DECISION DELEGATED TO DEVELOPMENT MANAGER

Application No: H07-0648-20 **Applicant:** T Nightingale

Proposal: Conversion of existing garage into habitable space and proposed rear extension

Location: Greenfields 7 Station Road Gedney Hill

Ground Floor GA Plan
Proposed - 1 to 50

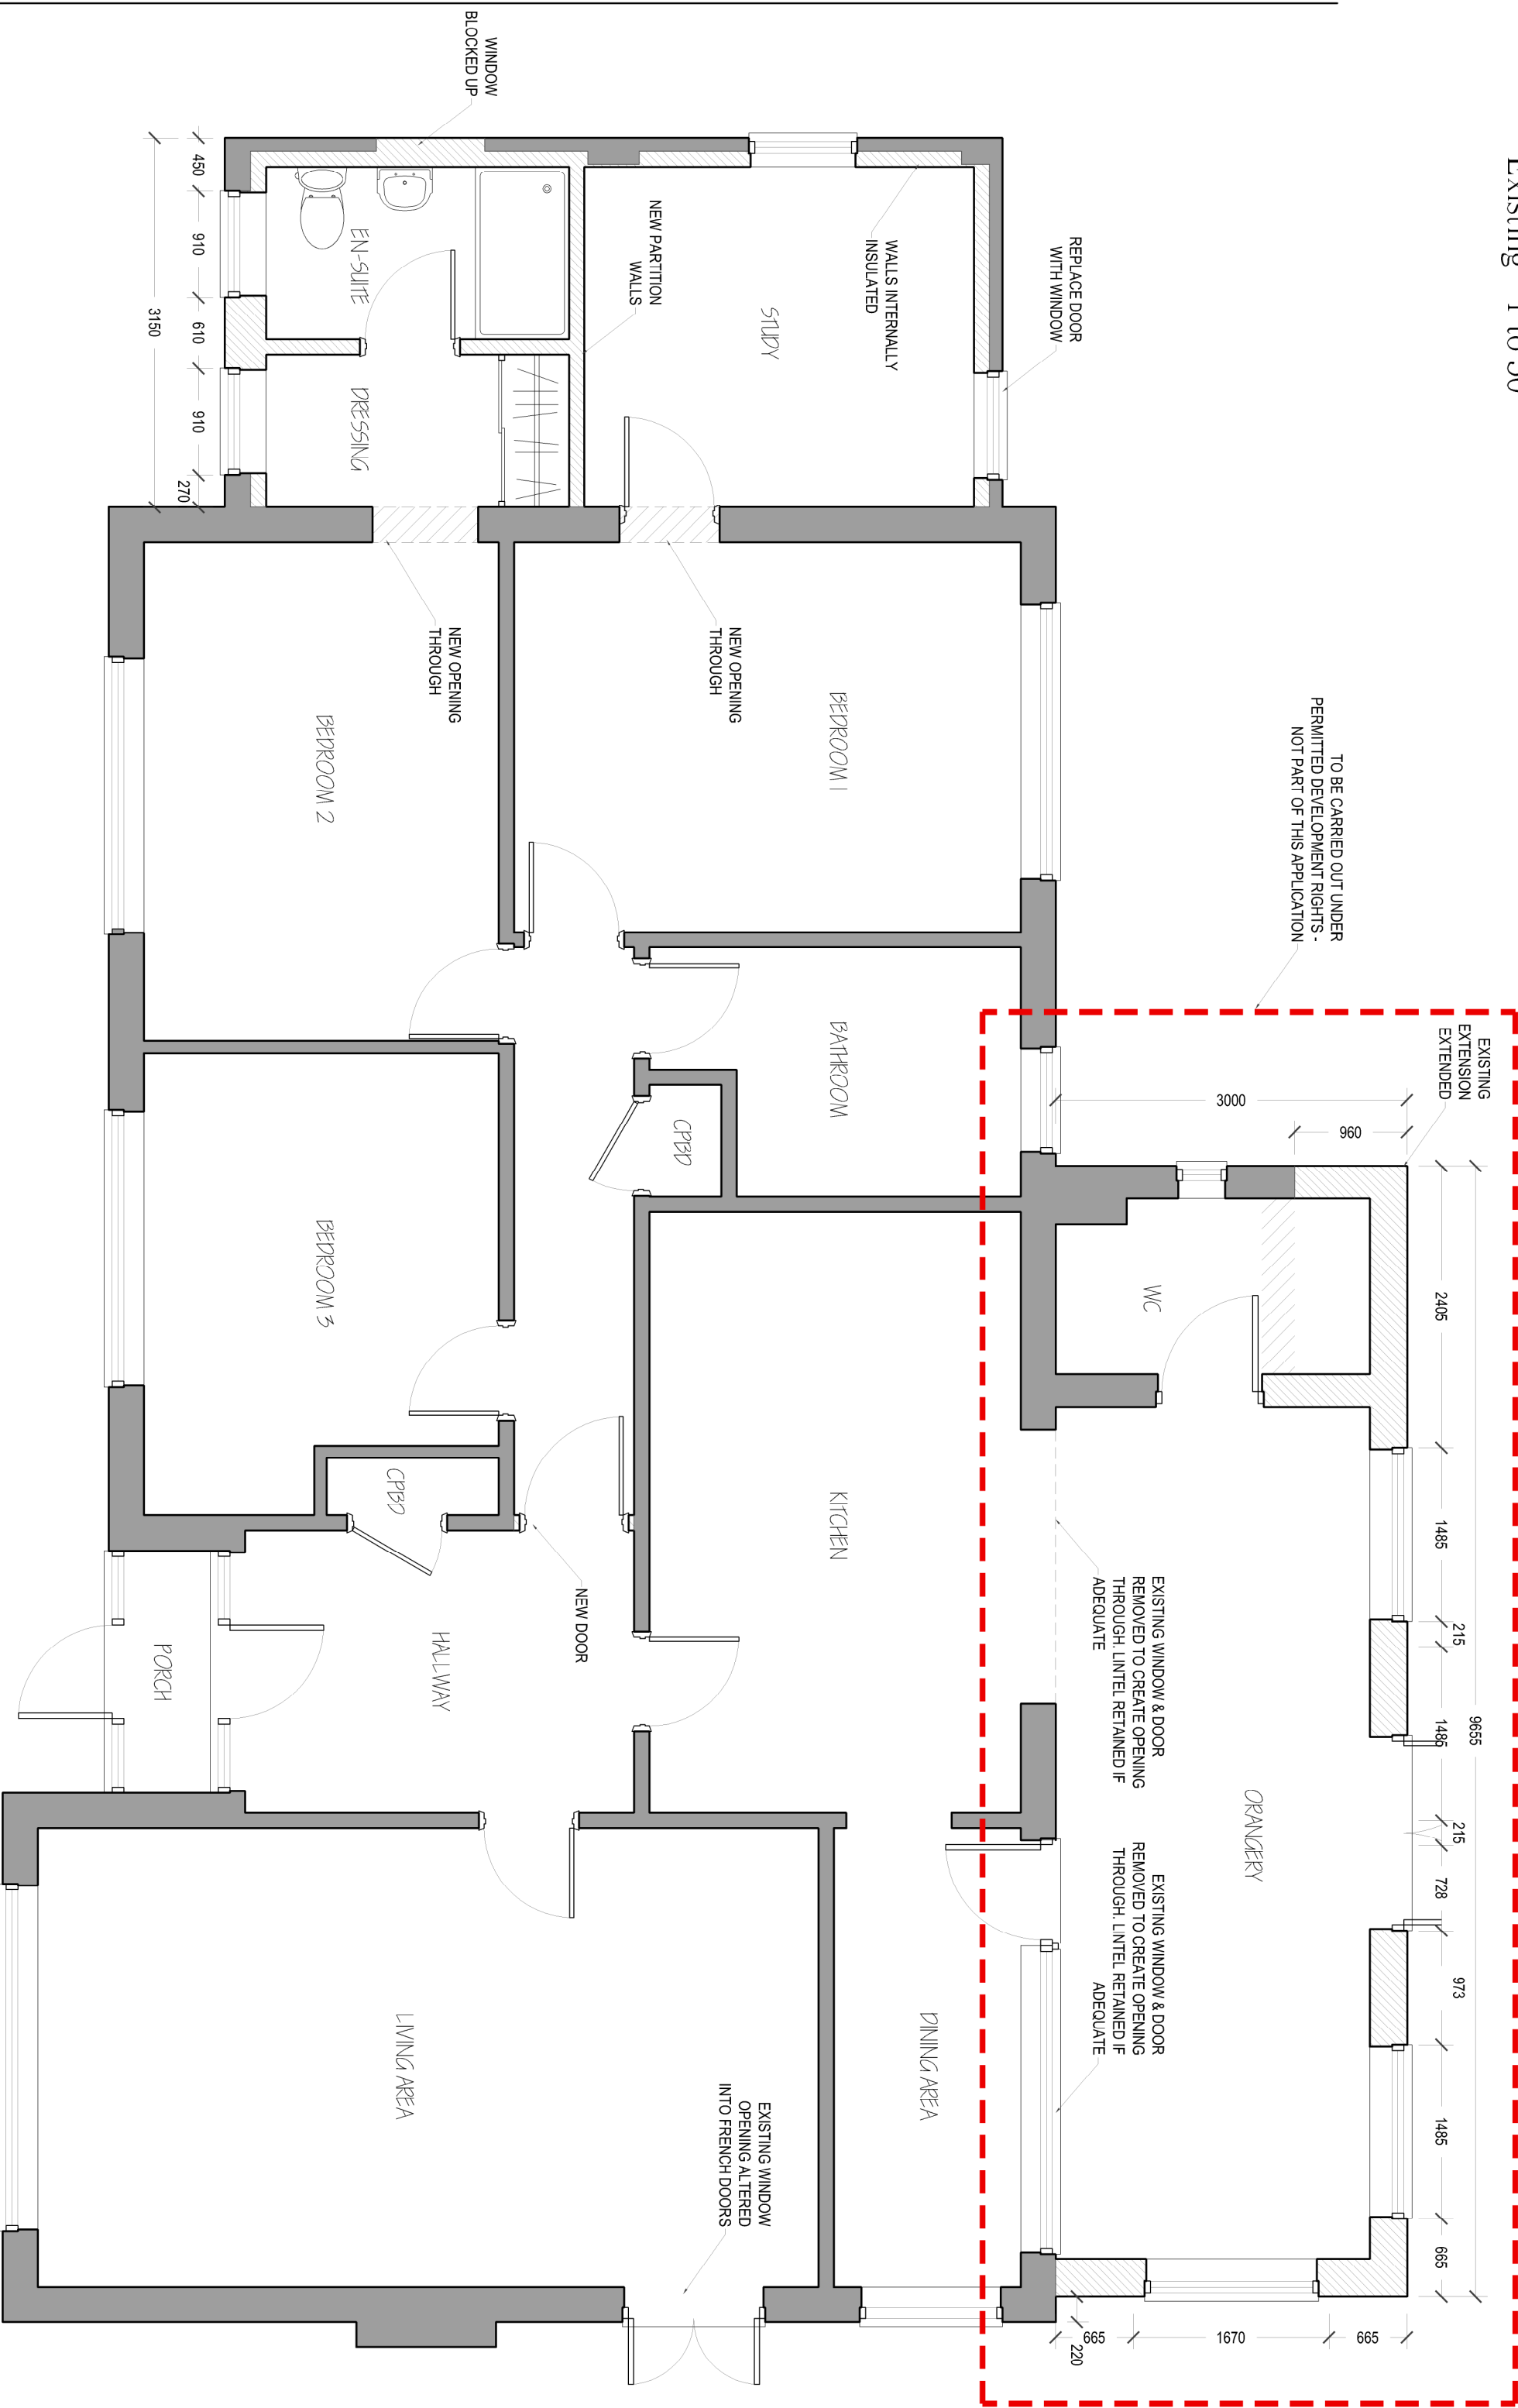
Internally, the two existing rear windows from where the proposed extension will be built are planned to be removed and create a larger opening to ensure access between the new room and the house. The aim of the development is to replace the conservatory into orangery. The proposed works also seek the enlargement of the existing toilet. The in-built garage will be also converted into a study room and the ensuite and dressing room for the adjacent front bedroom. New partition walls and replacement of openings are deemed acceptable as they are functionally necessary to undertake the conversion.

Rear (S-E) Elevation
Proposed - 1 to 50

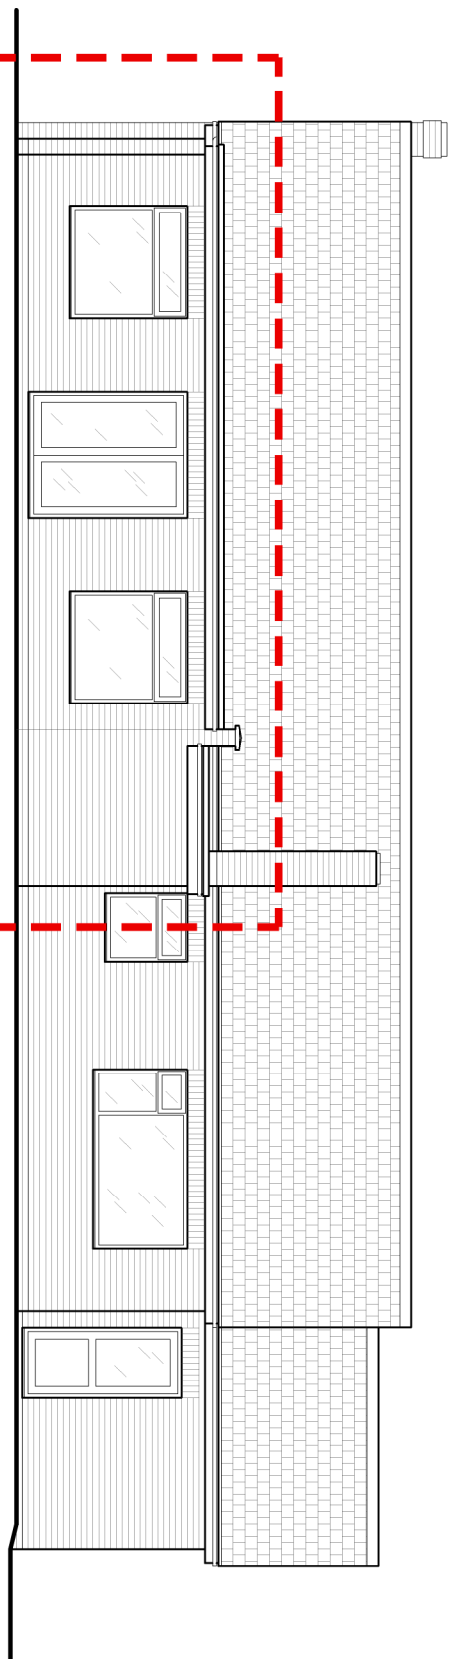
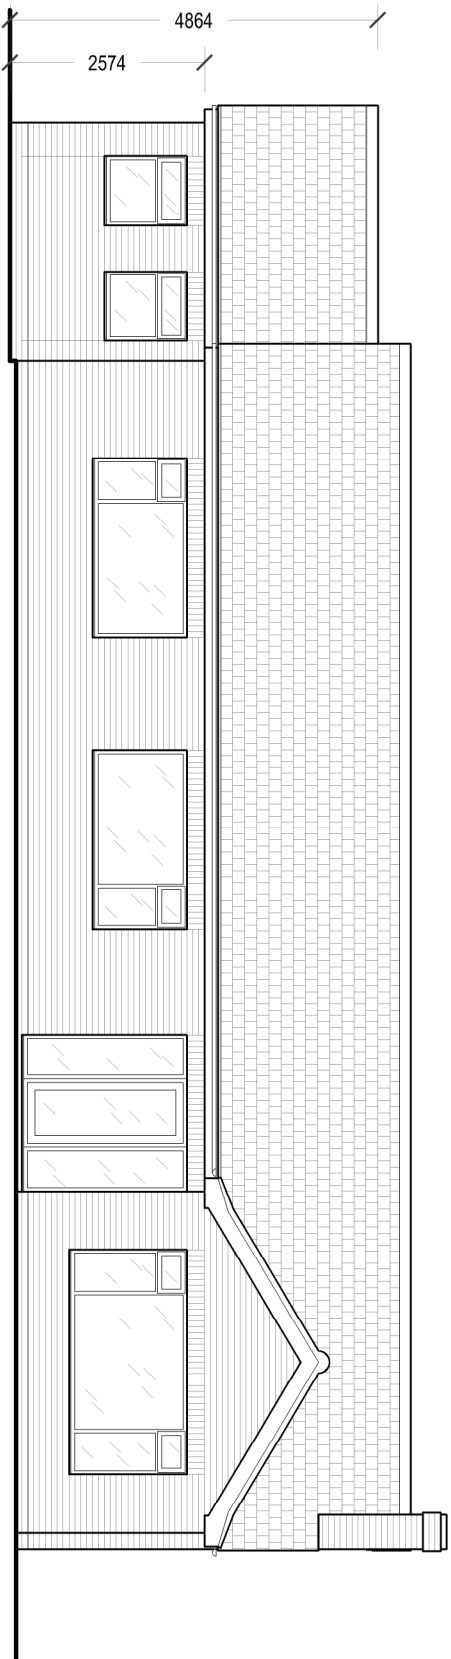
The property currently benefits from a subsequent rear extension that accommodates a toilet and conservatory. The conservatory and the rear brick wall of the toilet will be demolished and the other walls will remain. From there, the proposed extension will be erected. The development will protrude 3 metres of the original rear wall of the bungalow and will extend 9.65 metres to join nearly the southern side wall. The maximum height will be 2.75 metres above ground levels.

The material increase will not be significant in comparison with the current rear addition to the bungalow. It is therefore considered that the development will be also subservient to the host property in terms of scale, mass and bulk. Furthermore, the outdoor amenity will nearly remain as the form of development will not encroach onto the rear garden which is in fact fairly sizeable.

# Block Plan

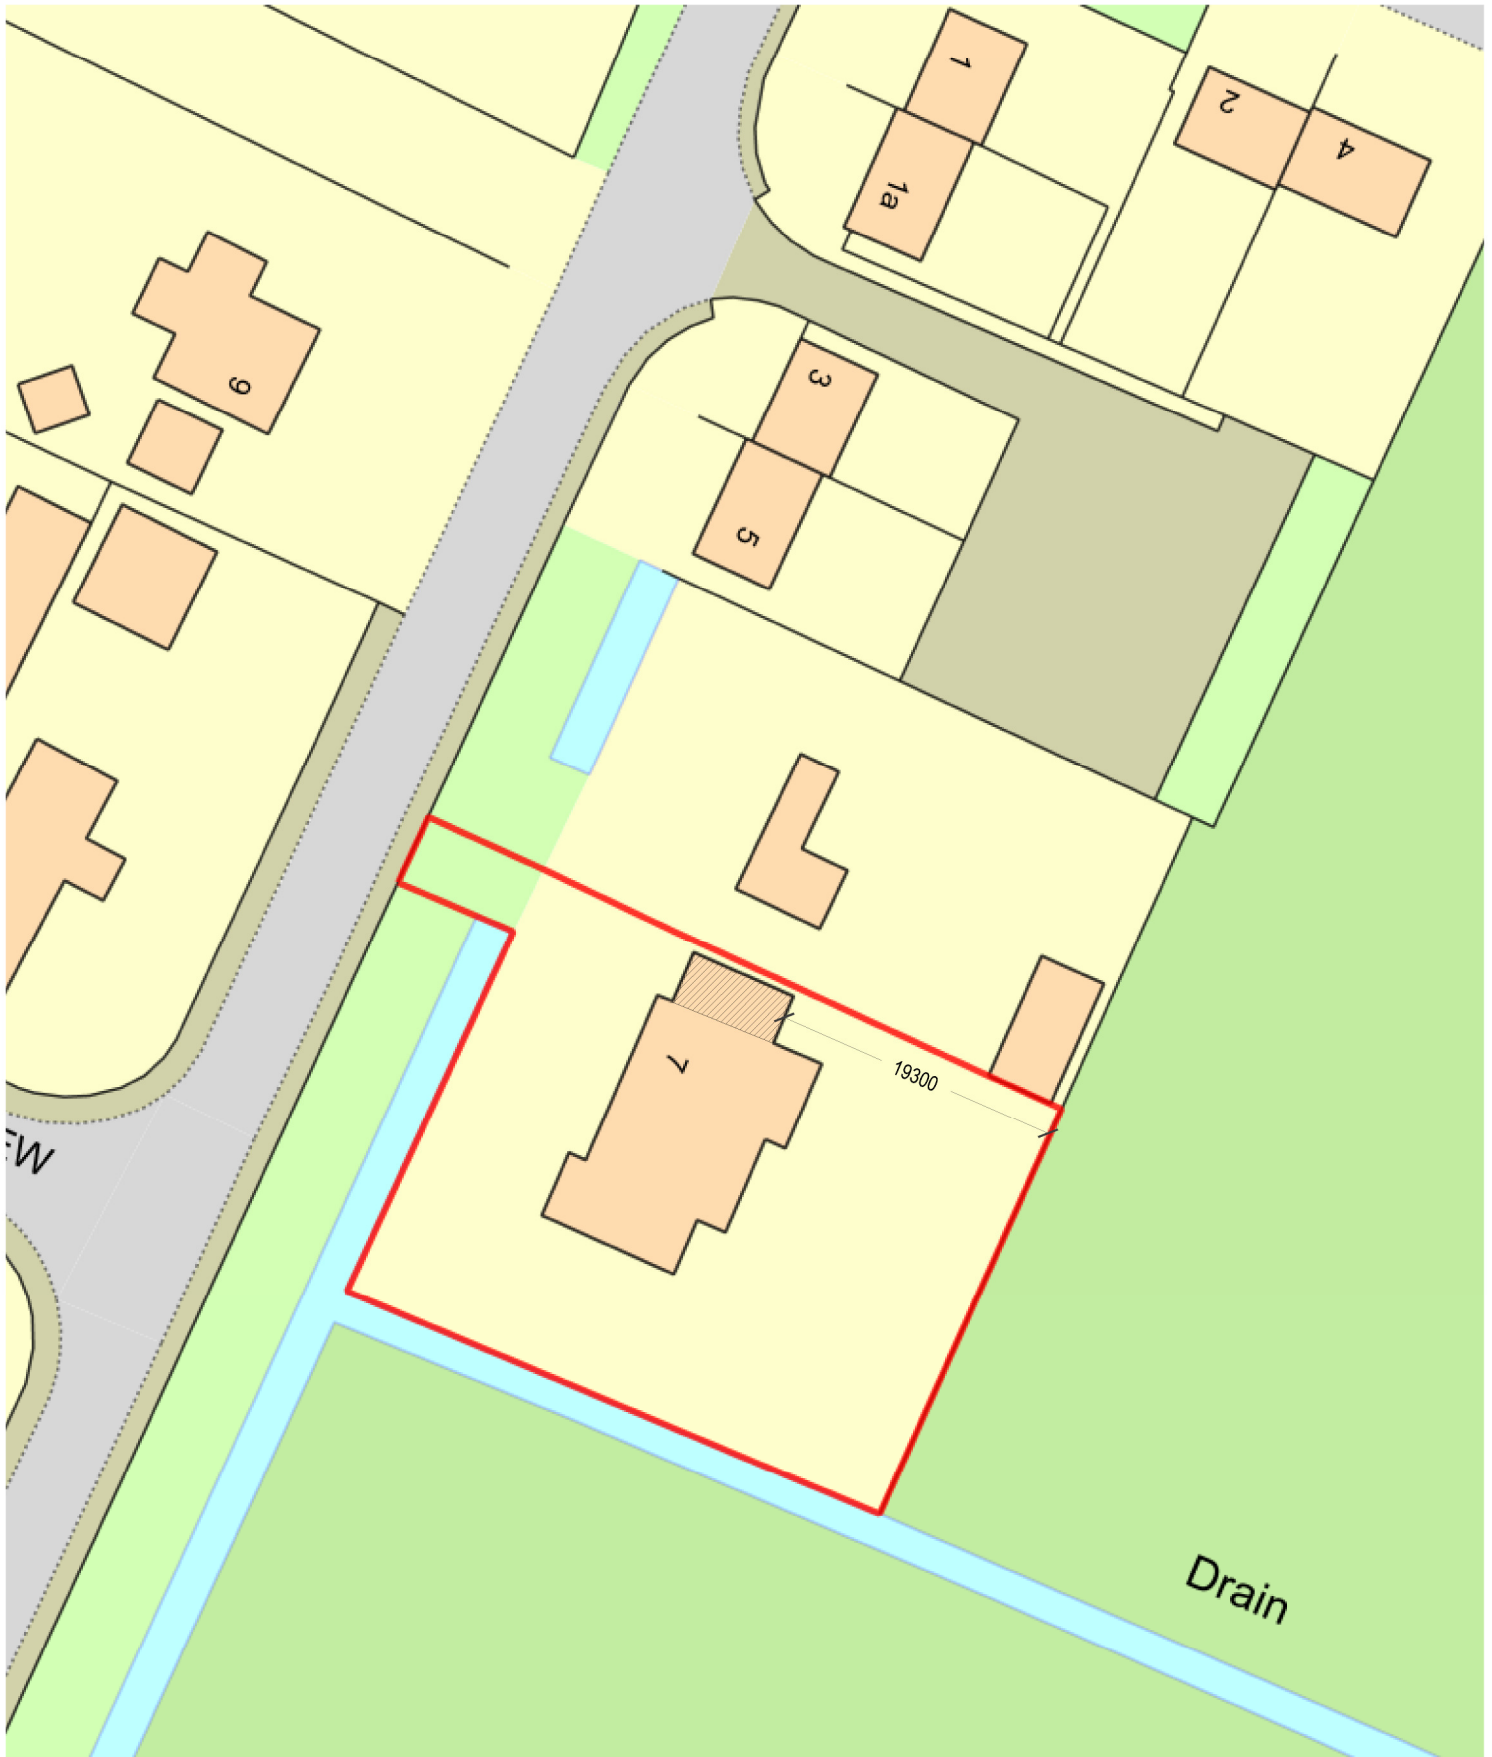
Should the intended orangery be used for regular or permanent bedroom space, the total number of bedrooms will rise up to 4. The annexed document establishes that 3 spaces for dwellings with 4 or more bedrooms should be ensured. Greenfields has a fairly long and wide gravelled drive. Three cars can be easily accommodated for parking. Thus, this application accords with Appendix 6 of SELLP.
